From: Patrick Yamashita
Sent: Monday, September 21, 2015 8:14 AM
To: Travis Saunders
Subject: Mercer Island Treehouse LLC (5637 EMW)

I've reviewed the Level 1 Storm Drainage Downstream Analysis for the Mercer Island Treehouse (Bill Summers) site. My comments are below including reference to several typos. I have also written my comments directly in the analysis.

Mercer Island Stormwater Conveyance Inventory Exhibit with Project Tributary Area

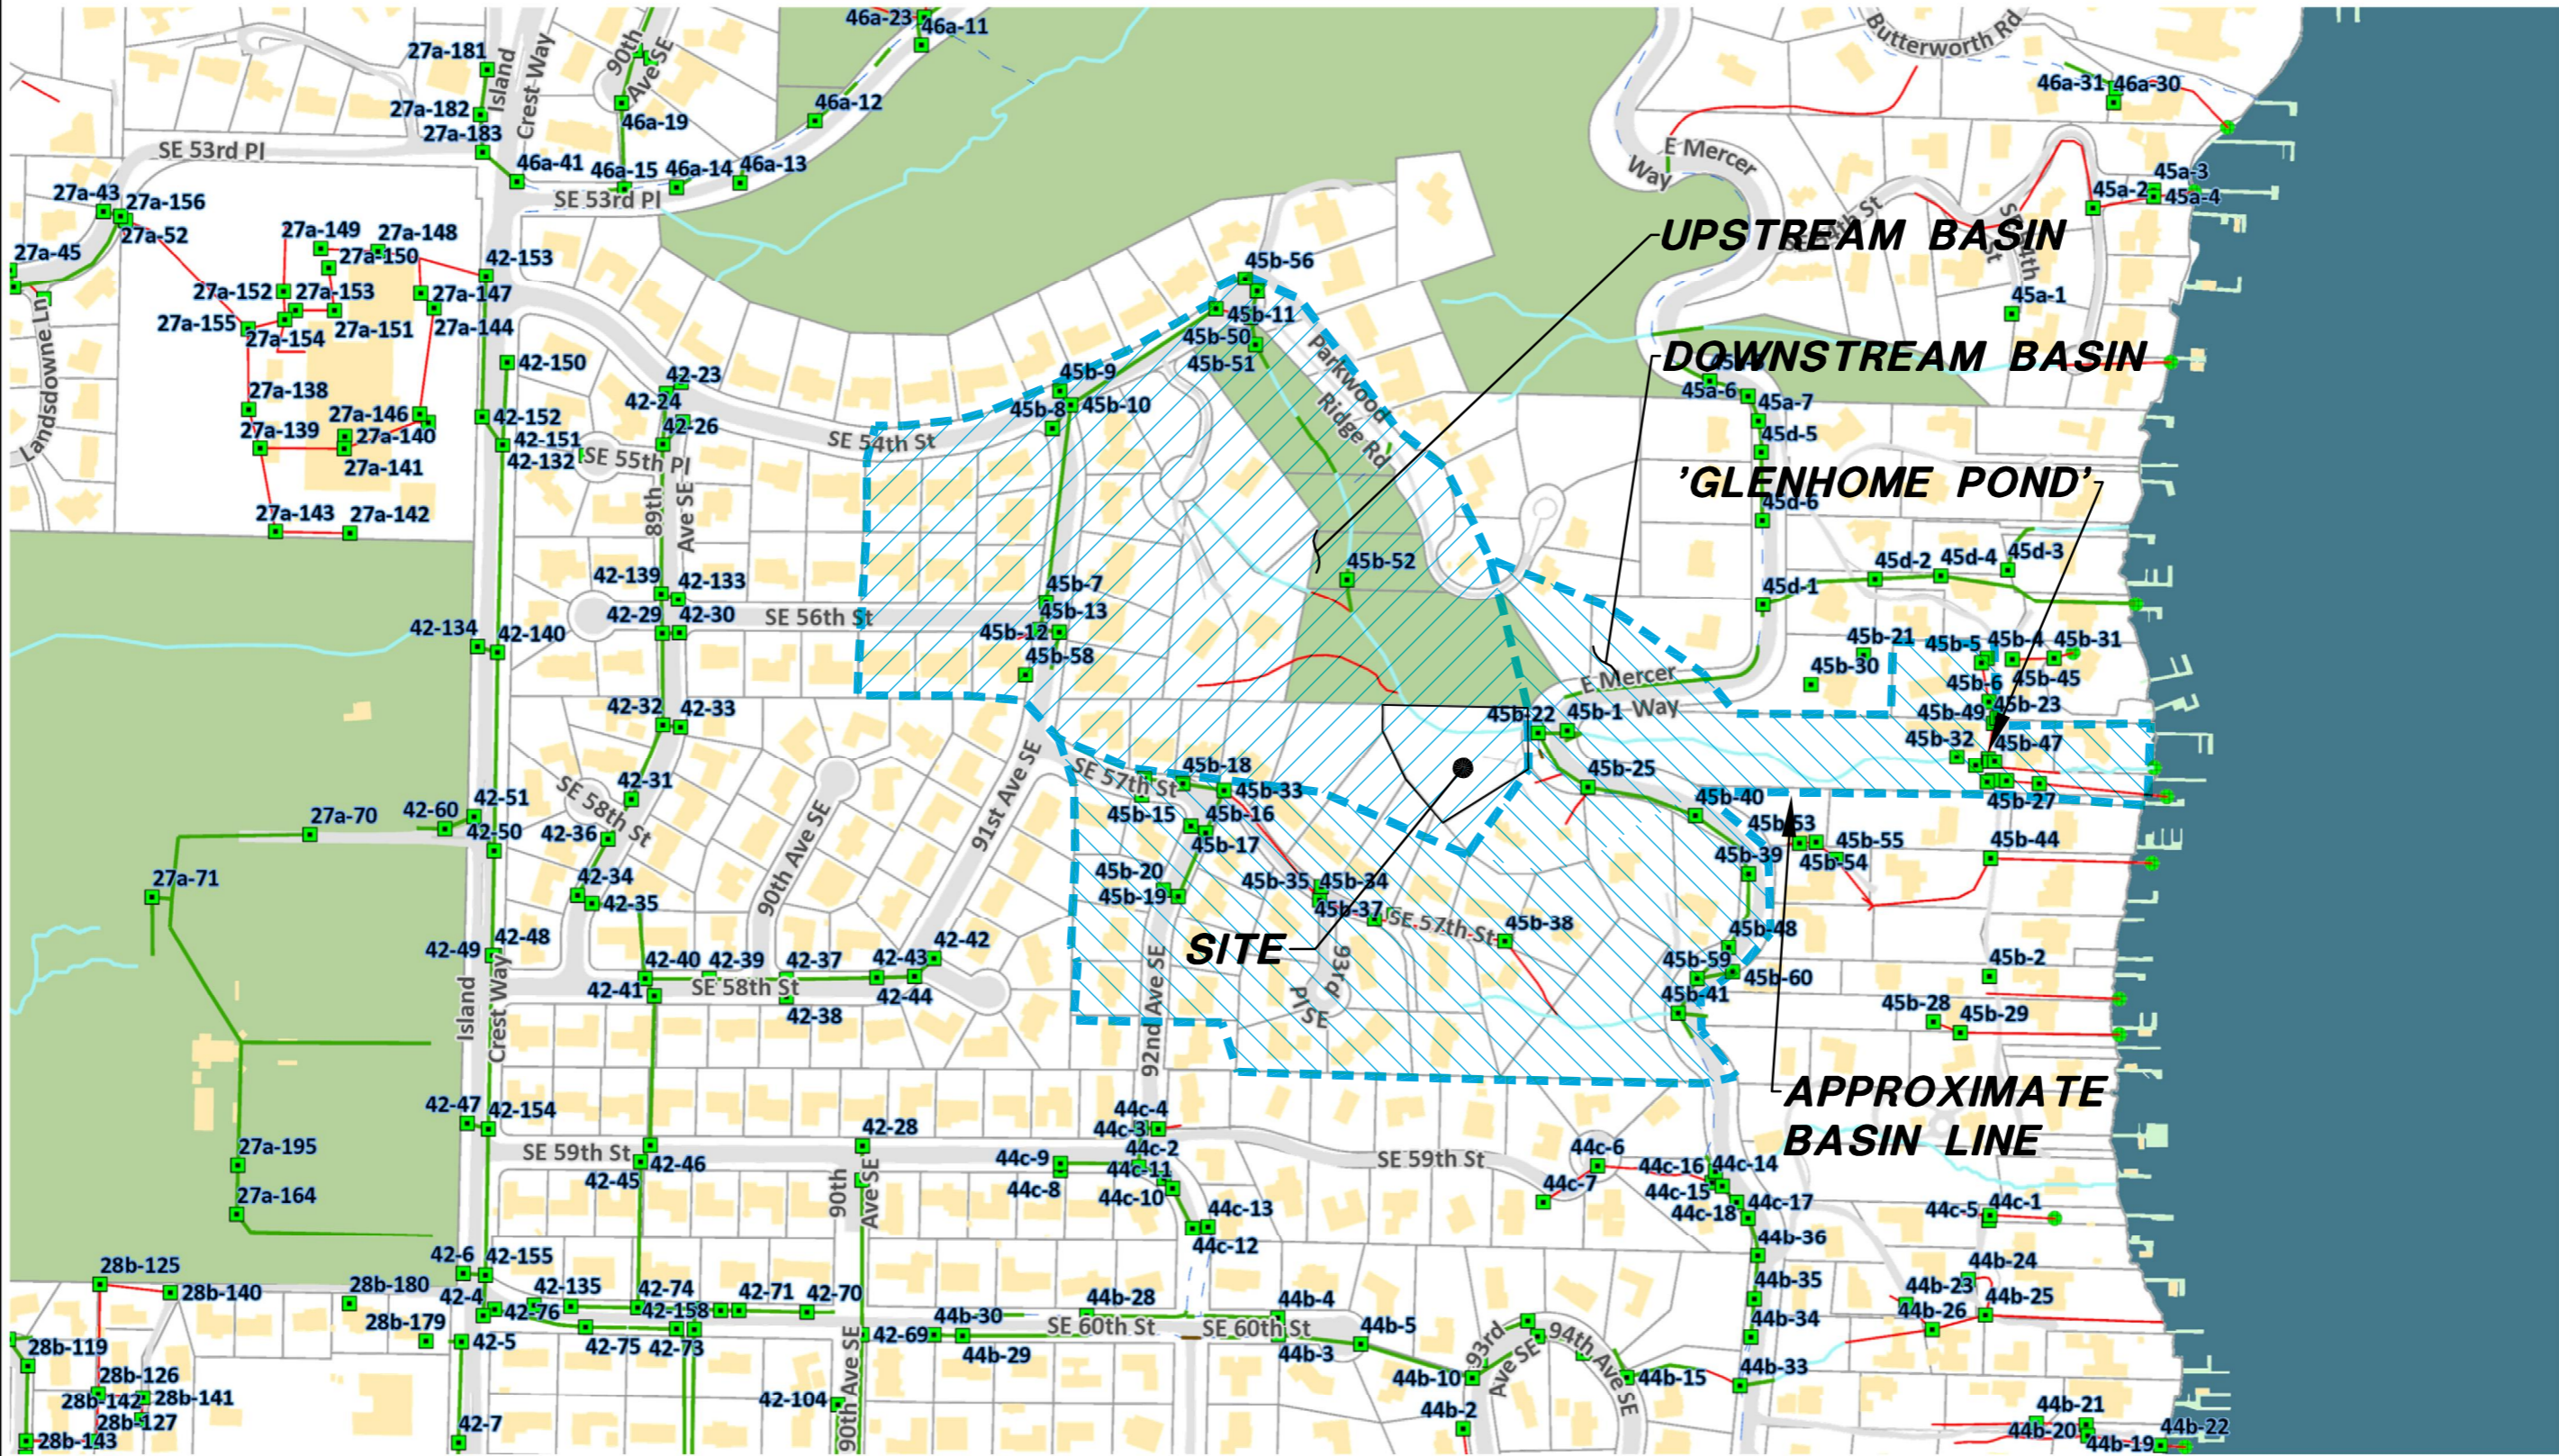
1. Pg. 1-1: The project address is shown as 5367 East Mercer Way. This is not correct. It is "5637".
2. Pg. 2-1 (Section 2.1): The tributary area is identified as 10.8 acres. The south boundary of the drainage basin appears incorrect. It should be further south based on topography.

8. Appendix A: Re-examine the delineation of the south basin boundary.
9. Appendix B: The drainage complaint log should be labelled consistently with the drainage complaints map.
